MODIFICATION REQUEST:
Mixed Use Development
44-46 Walker Street, Rhodes
MP 10_0105 MOD 1

Director-General's
Environmental Assessment Report
Section 75W of the
Environmental Planning and Assessment Act 1979

September 2012

PARKING SCHEDULE - BASEMENT - 01	
PARKING TYPE	NUMBER
Standard Residential	261
Adaptable Residential	30
Standard Retail	9
Motorbike	2
TOTAL	322

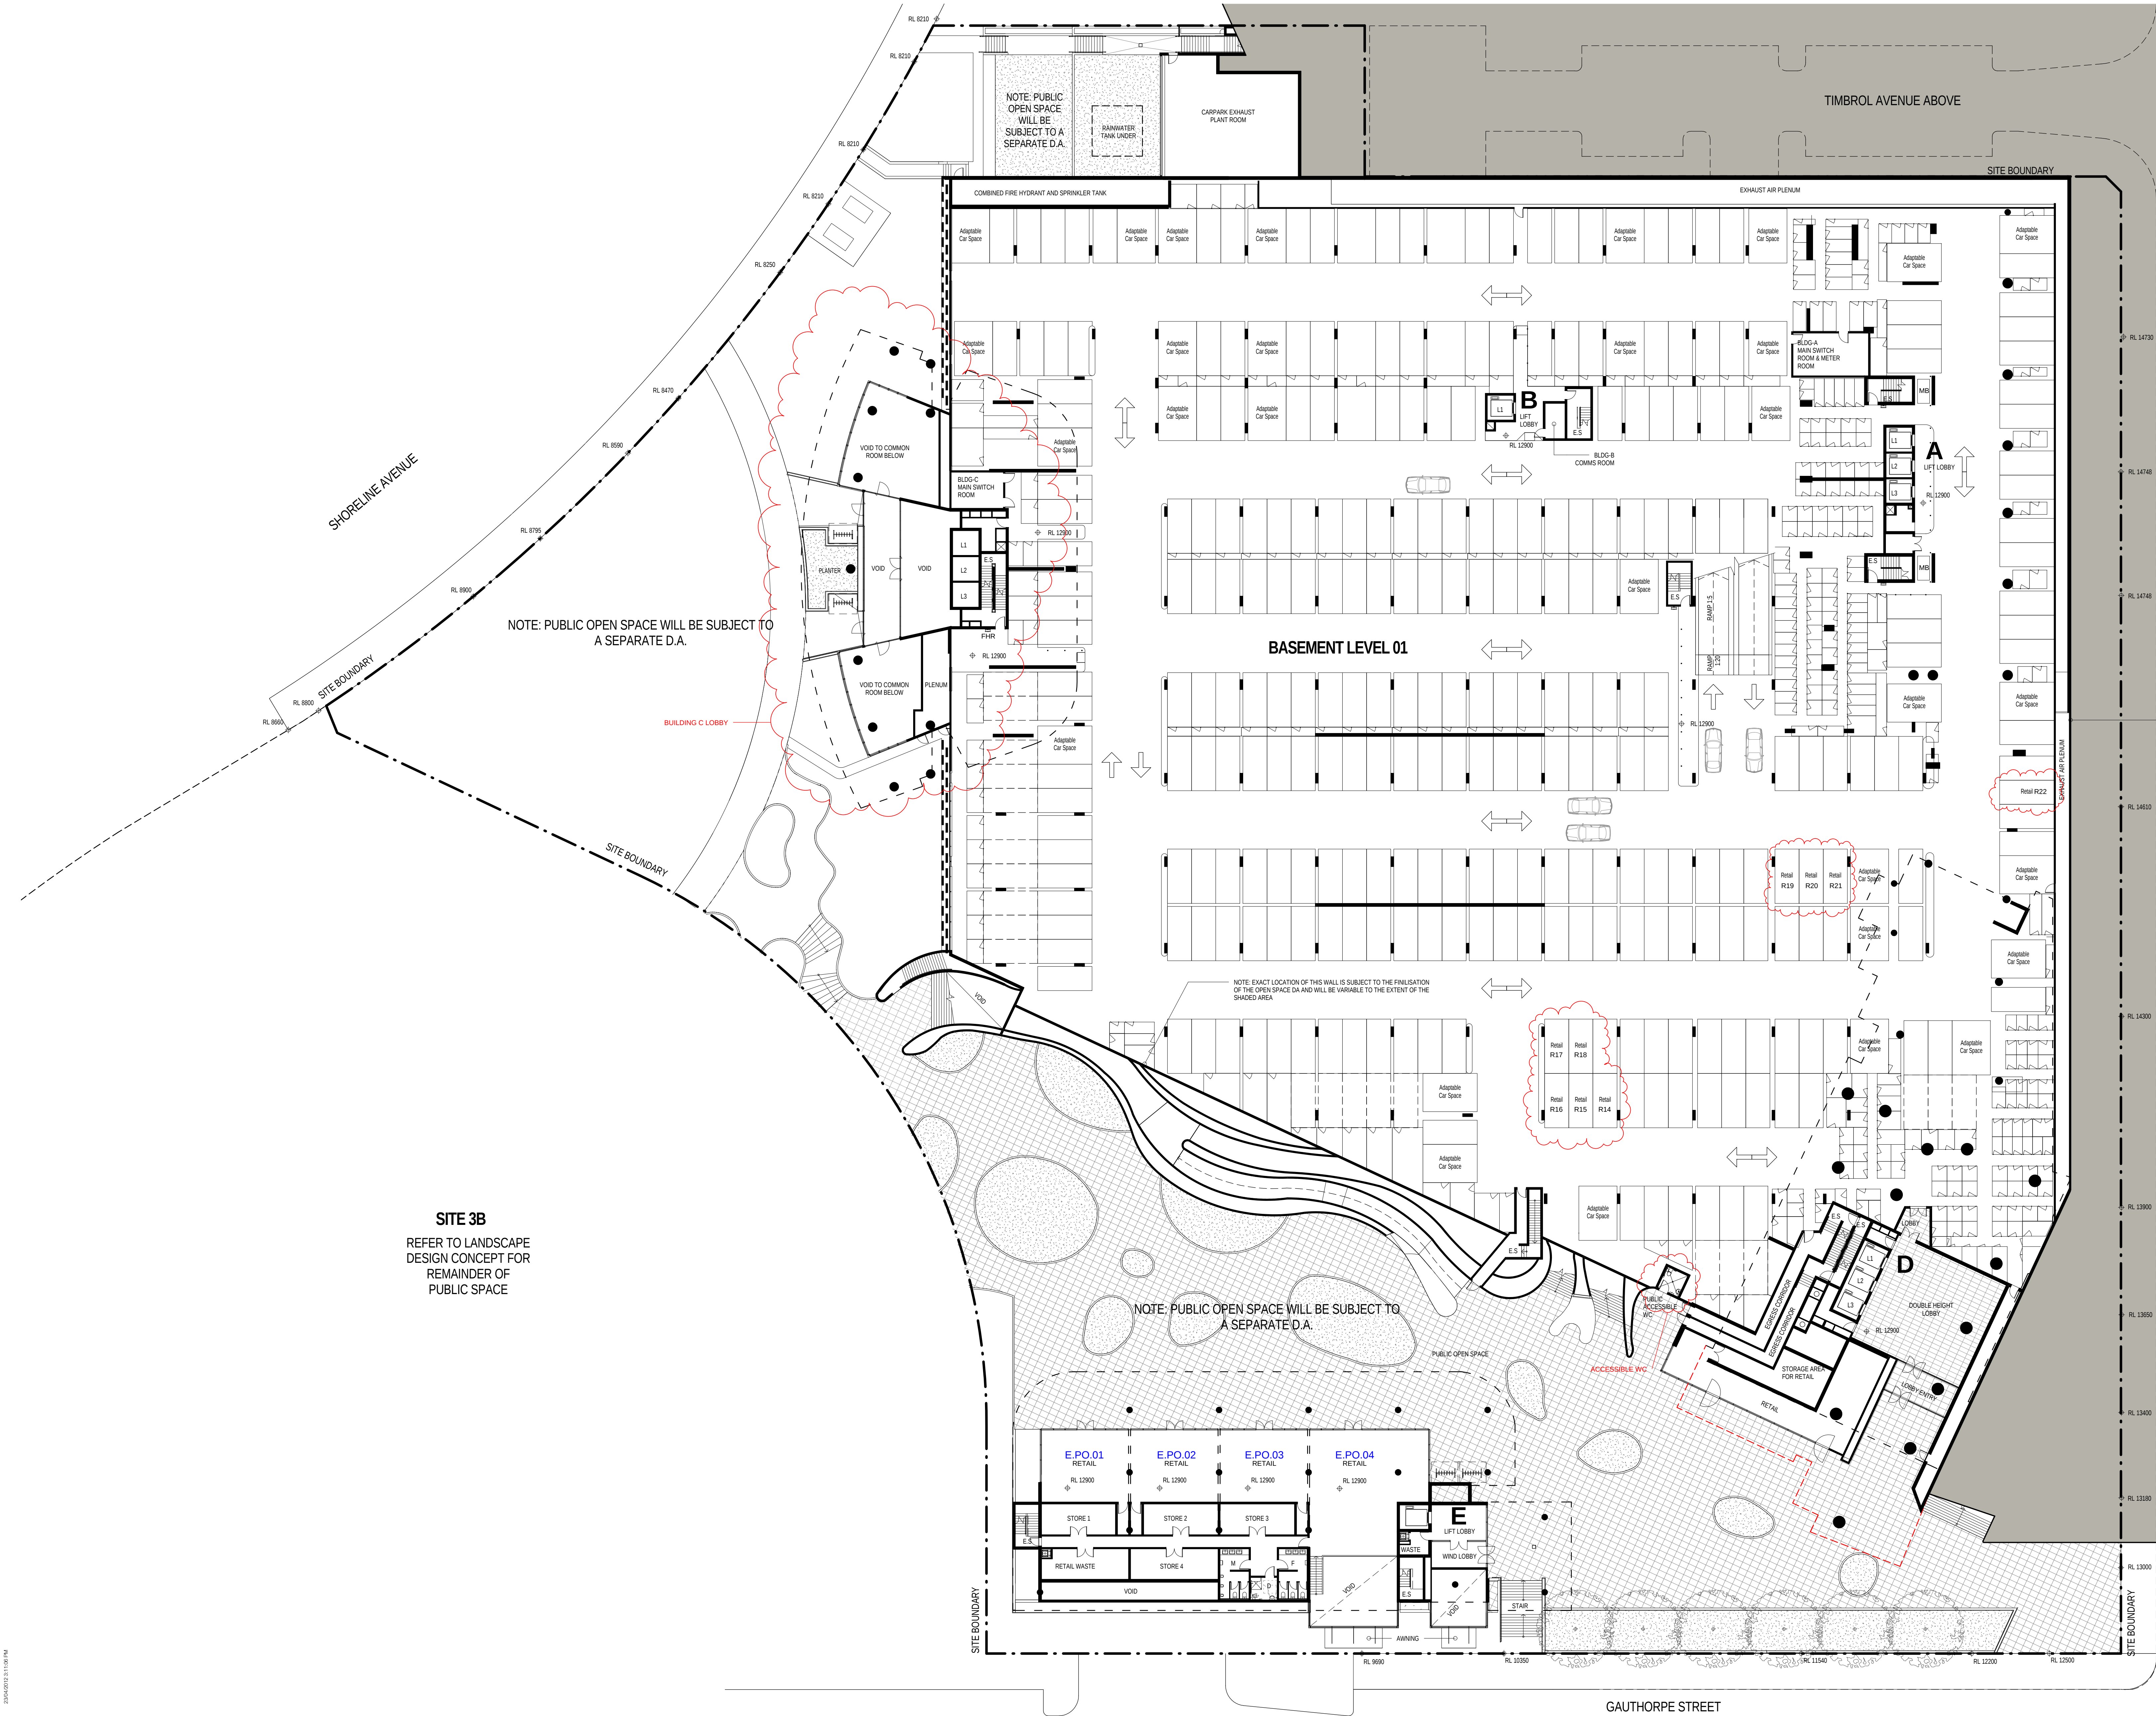
Of the 735 units approved as part of the development, 111 are designated adaptable housing units (AHUs), of which each has been allocated an adaptable car parking space with a required minimum width of 3.8m. The proponent originally sought a

reduction of 36 adaptable car parking spaces (from 111 to 75), whilst increasing the number of retail car parking spaces by 14 (from eight to 22).

Council advised in its submission that in accordance with the Rhodes West DCP, one car parking space per AHU is to be provided within new developments, with adaptable car parking spaces to have a minimum width of 3.8m. Council advised, however, that it would be amenable to reducing the width of adaptable car parking spaces to be consistent with the width required for disabled car parking spaces (from 3.8m to 3.6m).

The department acknowledges the site's proximity to public transport services, including Rhodes railway station, however, the proposed reduction of adaptable car parking is not supported given the importance of providing those tenants living in adaptable units with an appropriately dimensioned car parking space. In addition, the Rhodes West DCP stipulates a requirement of one adaptable car parking space per AHU. The department therefore requested the proponent to consider either a revised car parking layout, or a reduction in retail GFA to ensure each AHU is allocated an adaptable car parking space.

The modification request originally proposed an increase of 14 retail car parking spaces to cater for the additional 298m² of retail GFA. The additional spaces were to be created at the expense of adaptable car parking, as discussed at **Section 5.1.2** above. As council and the department were not supportive of reduced adaptable car parking, the proponent provided revised car parking plans with an allocation of only three additional retail car parks.

The proponent subsequently provided revised car parking plans outlining an allocation of one adaptable car parking space per AHU, with a reduced car parking width from 3.8m to 3.6m – consistent with the width required for disabled car parking spaces. The department is satisfied with the proposed adaptable car parking arrangement. The revised plans, however, only provide for an increase of three retail car parking spaces, as discussed at **Section 5.1.3**.

public transport. The proposed increase of three retail spaces to 11 in total will see an average of 1 retail car park per 123m² of retail GFA. The proposed retail car parking allocation is consistent with the department's original approval of 1 space per 131m². The department acknowledges the inconsistency with the Rhodes West DCP, however, it is considered that a substantial number of the retail customers will be residents of the units above who will not require a retail car parking space. The department is satisfied with the proposed increase of three retail car parking spaces.

Drawing Name
Podium Plan

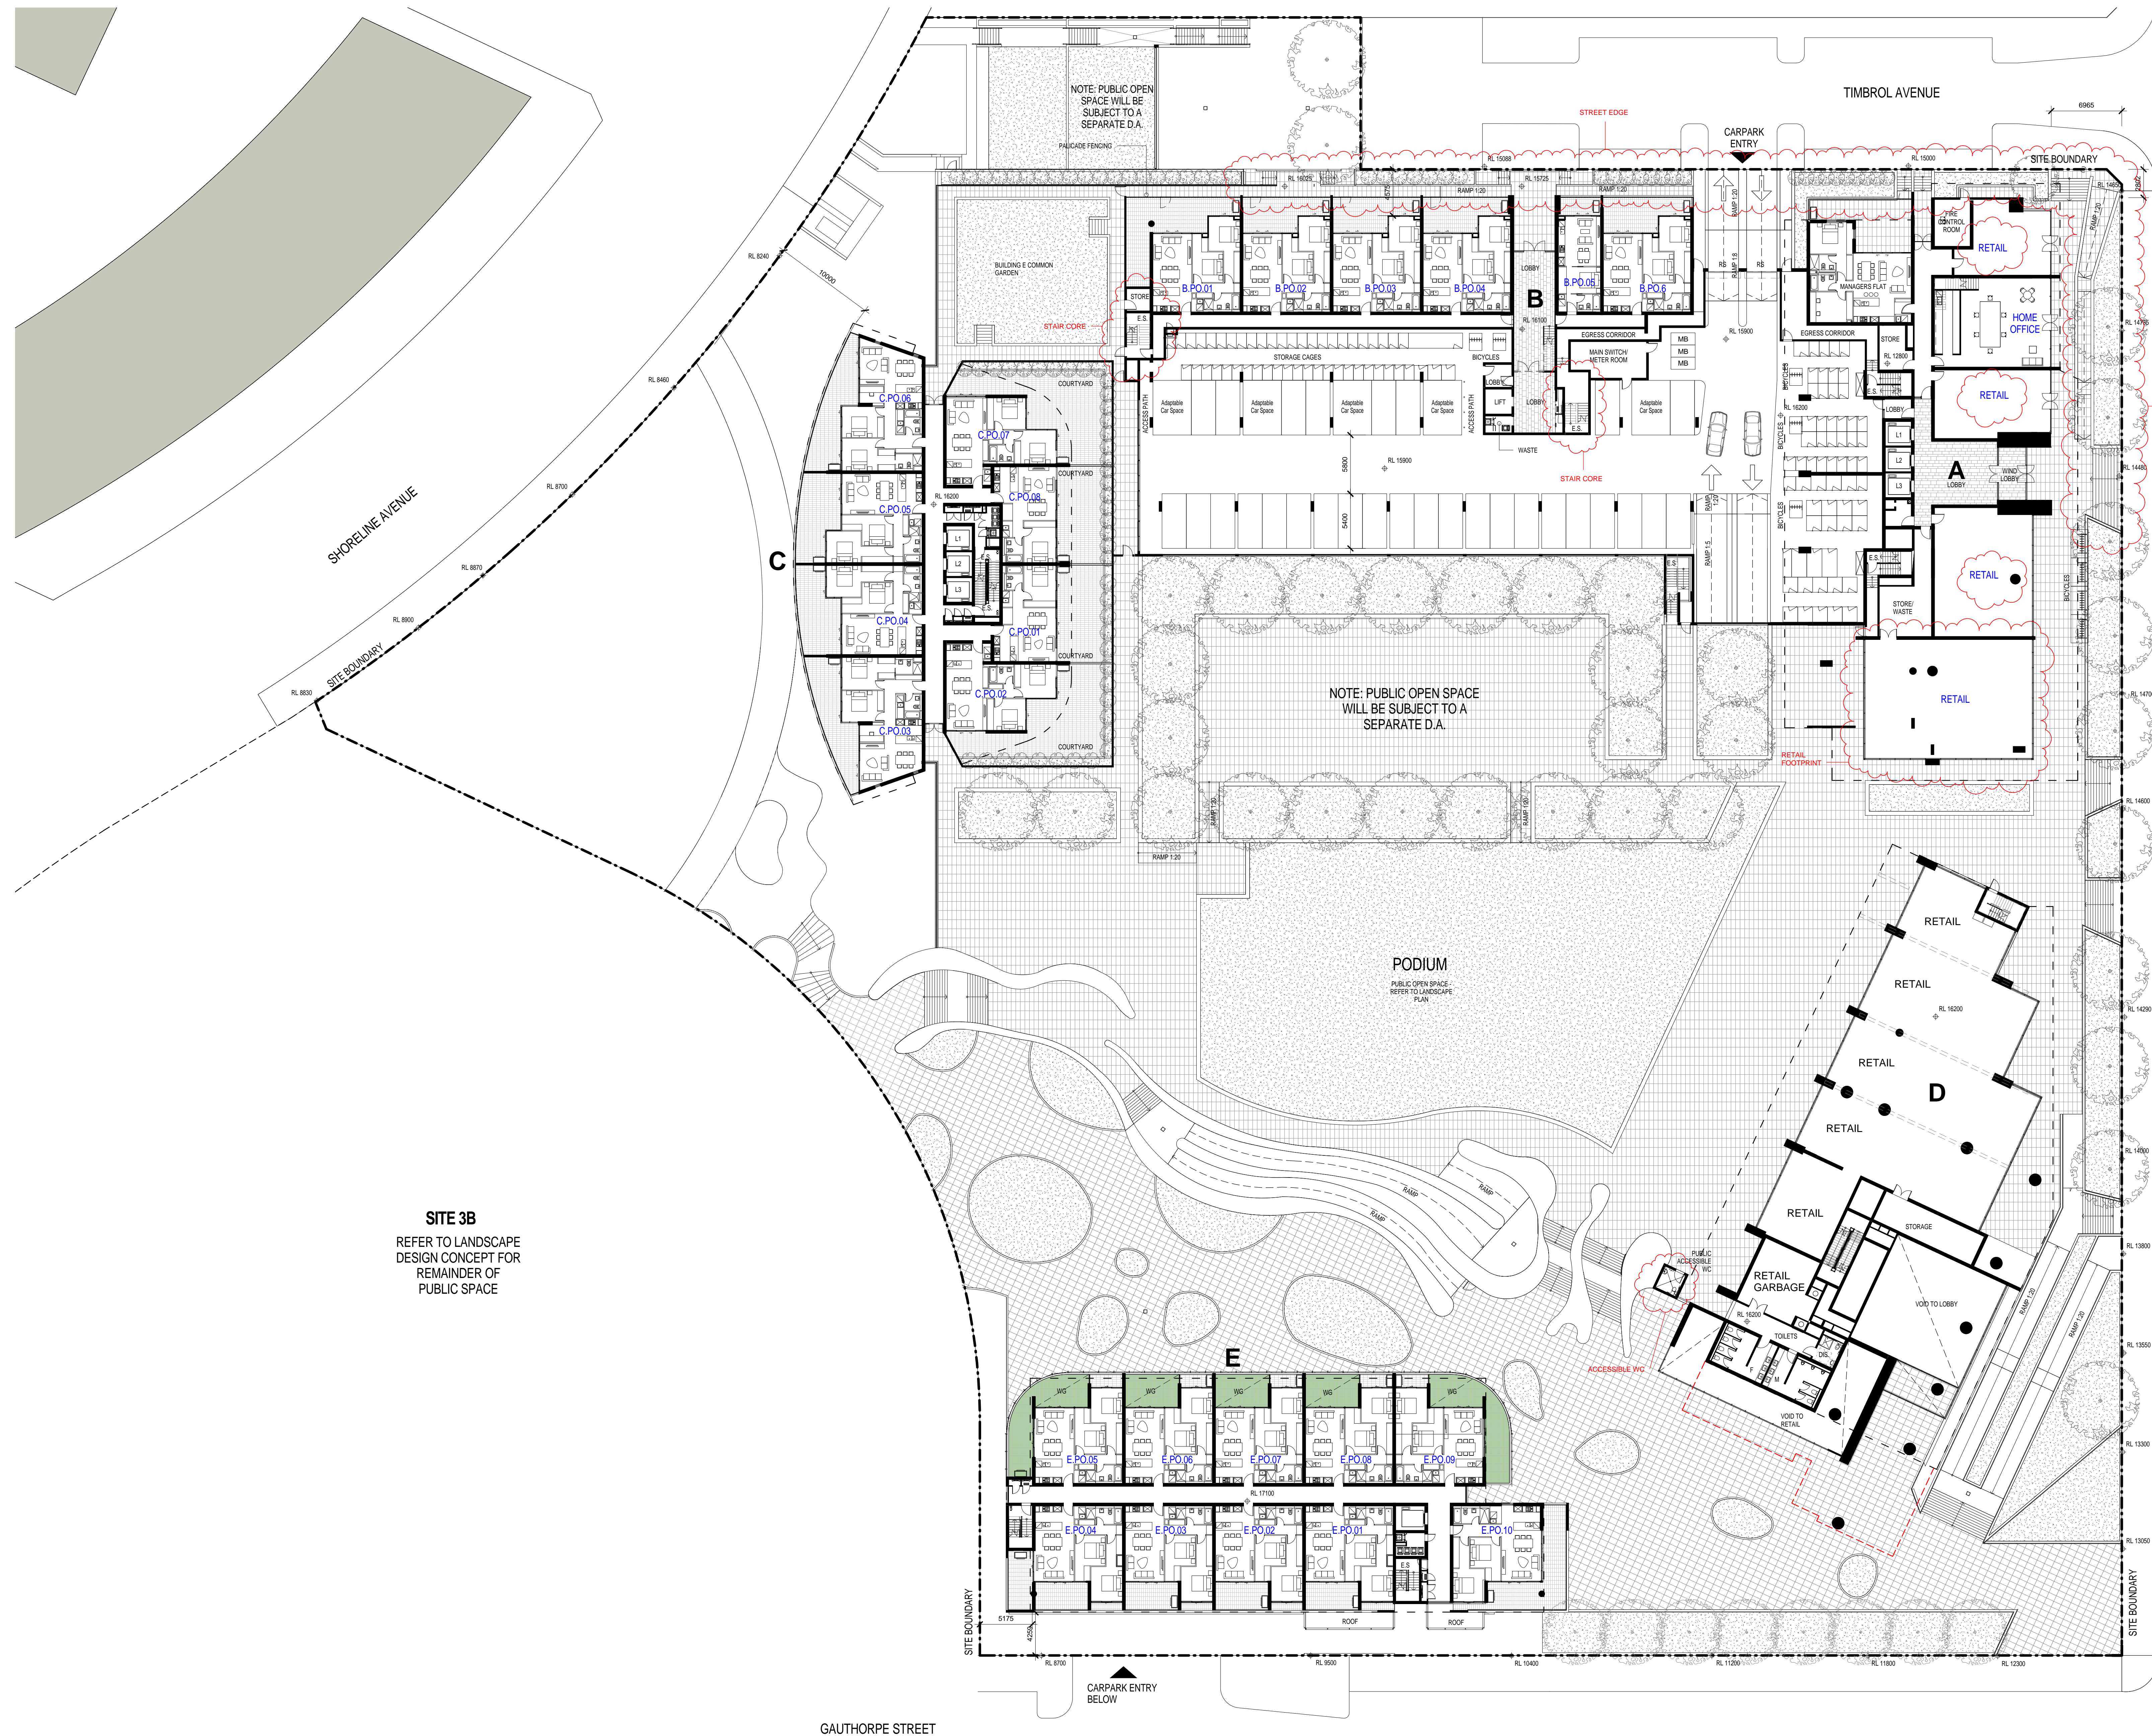
The proposed modification involves the conversion of two home offices and a common room approved for the podium level of Building A to be converted to retail tenancies. This will result in an additional 298m² of retail gross floor area (GFA) within Building A, bringing the total retail GFA of the site to 1,348m². **Figure 3** shows the location of existing retail at podium level (as part of Building D), and the location of proposed new retail tenancies at podium level within Building A.

The change of use is proposed in order to provide additional retail with continual frontage to the site's main thoroughfare of Walker Street. The proponent has advised that the additional common room facilities within Building C, also proposed as part of the modification, will compensate for the loss of common rooms within Building A given these rooms can be made available for occupants of the other buildings for meetings and communal activities.

Council did not raise any concern regarding increased retail use at the site. It is noted that the development controls for Precinct B, as outlined in the Rhodes West DCP, states that the preferred location for non-residential uses including retail and commercial uses is along the Walker Street frontage and fronting onto the diagonal pedestrian plaza from the south-east corner of the site. The department considers that the additional retail tenancies are located in a desirable position along the main street frontage of Walker Street, and therefore raises no concern with the increase in retail use. The additional retail GFA does, however, have implications on the approved car parking arrangement, as discussed further at **Sections 5.1.2 and 5.1.3**.
